15 December 2022

Re: Bowdens Silver Project – Surface Water Peer Review Conclusions and Recommendations

Following review of the *Update on Independent Review – Water Balance Modelling and Surface Water Management* prepared by Earth Systems we have prepared response to the final comments, focusing on the conclusions and recommendations of the review.

Figure 23 – Southern barrier maximum development (Year 12).

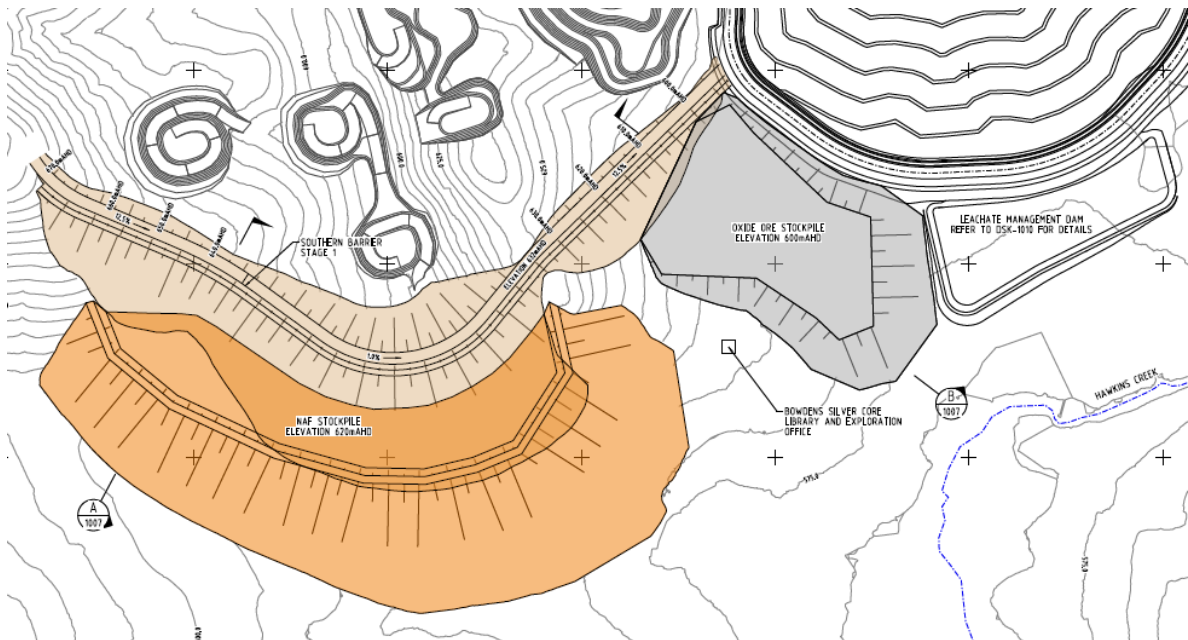
Review Item	Conclusions and Recommendations	Response
5	It is understood that Blackmans Gully would flow beneath the Southern Barrier (a “NAF” waste rock dump) and discharge off site, but there appears to remain a risk of drainage/seepage from the barrier entering Blackmans Gully. The Southern Barrier design should include provision for containment of all drainage (runoff or seepage) from the barrier and/or a contingency plan should be developed for Blackmans Gully.	The diversion of flows from upstream clean catchments beneath the southern barrier does not pose a risk to downstream water quality as this water would be conveyed by diversion drains and pipes/culverts and unlikely be in contact with NAF waste rock. However, there would be no water quality implications should diverted runoff come into contact with the upslope batter toe of the southern barrier as it would be constructed using benign waste rock material from the Sydney Basin sediments (WZ1). All runoff from the southern barrier itself would be collected in two downslope containment dams (refer Section 4.6.2 of WRM [2022] and Figure 3.1 of RWC [2022]).
